# FIVE ESTUARIES OFFSHORE WIND FARM

## 10.26.2 APPLICANT'S COMMENTS ON HISTORIC ENGLAND'S DEADLINE 2 SUBMISSIONS

| Document Number:       | 10.26.2       |
| Date:                  | November 2024 |

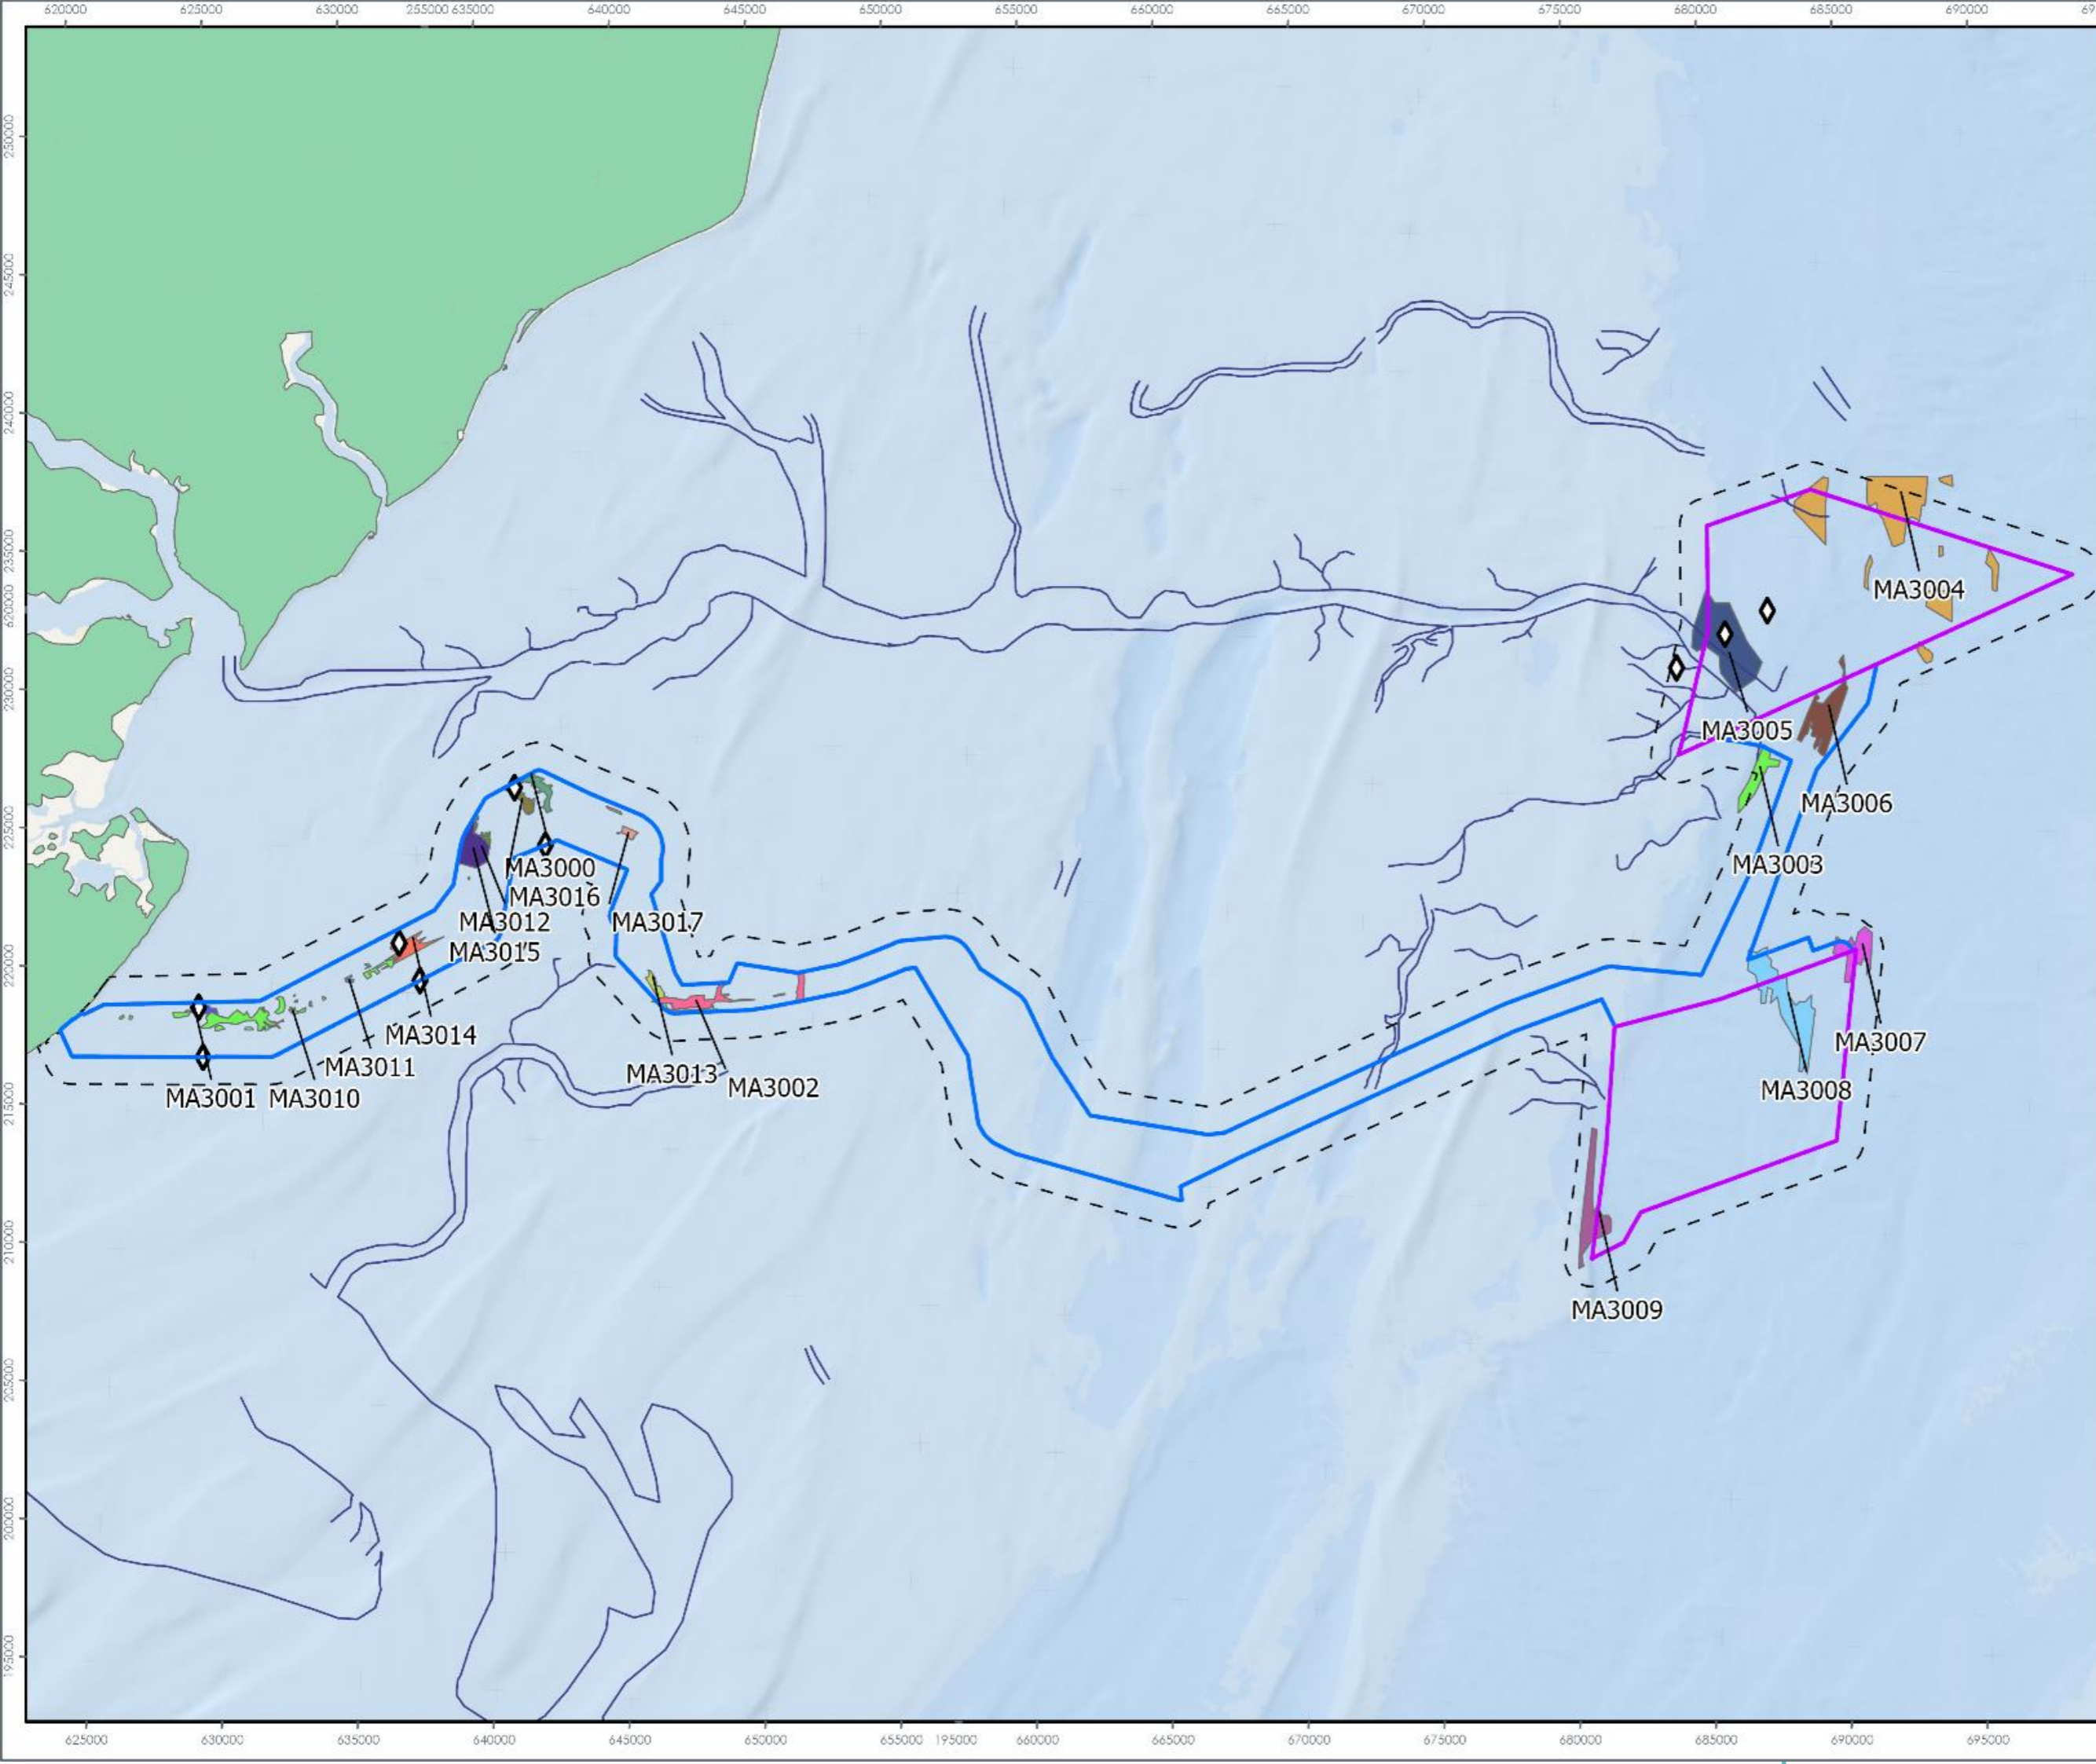
| Ref    | Summary of Deadline 2 submission OR Excerpt of Deadline 2 submission  | Applicant's comments   |
|--------|---|--|
| HE1.20 | Figure 6.12 It is noted that only nine possible geotechnical cores are indicated here, which we consider to be a low number. This is taking into consideration the number and size of channels identified. We feel that this number should be reconsidered, and further work is required.   | <p>Figure 612 illustrates, preliminary, archaeological core locations which have been recommended in addition to forthcoming geotechnical cores based on sub-bottom data and desk-based data. It is likely that these will be refined in an activity specific Method Statement ahead of any geoarchaeological works, also see updates to Section 8.4 in Volume 9, Report 19: Outline Marine Written Scheme of Investigation (OMWSI).</p> <p>Further, the Applicant agrees that further geoarchaeological works will be undertaken in line with Table 11.17: Mitigation relating to Offshore Archaeology and Cultural Heritage, Volume 9, Report 19: Outline Marine Written Scheme of Investigation (OMWSI) and Deemed marine licence Schedule 10 Condition 12(2) (3), Condition 13, 16 (a) (iii), Condition 17 (2) (iii) Condition 18 (2) (a), Condition 19 (2) (a).</p> |
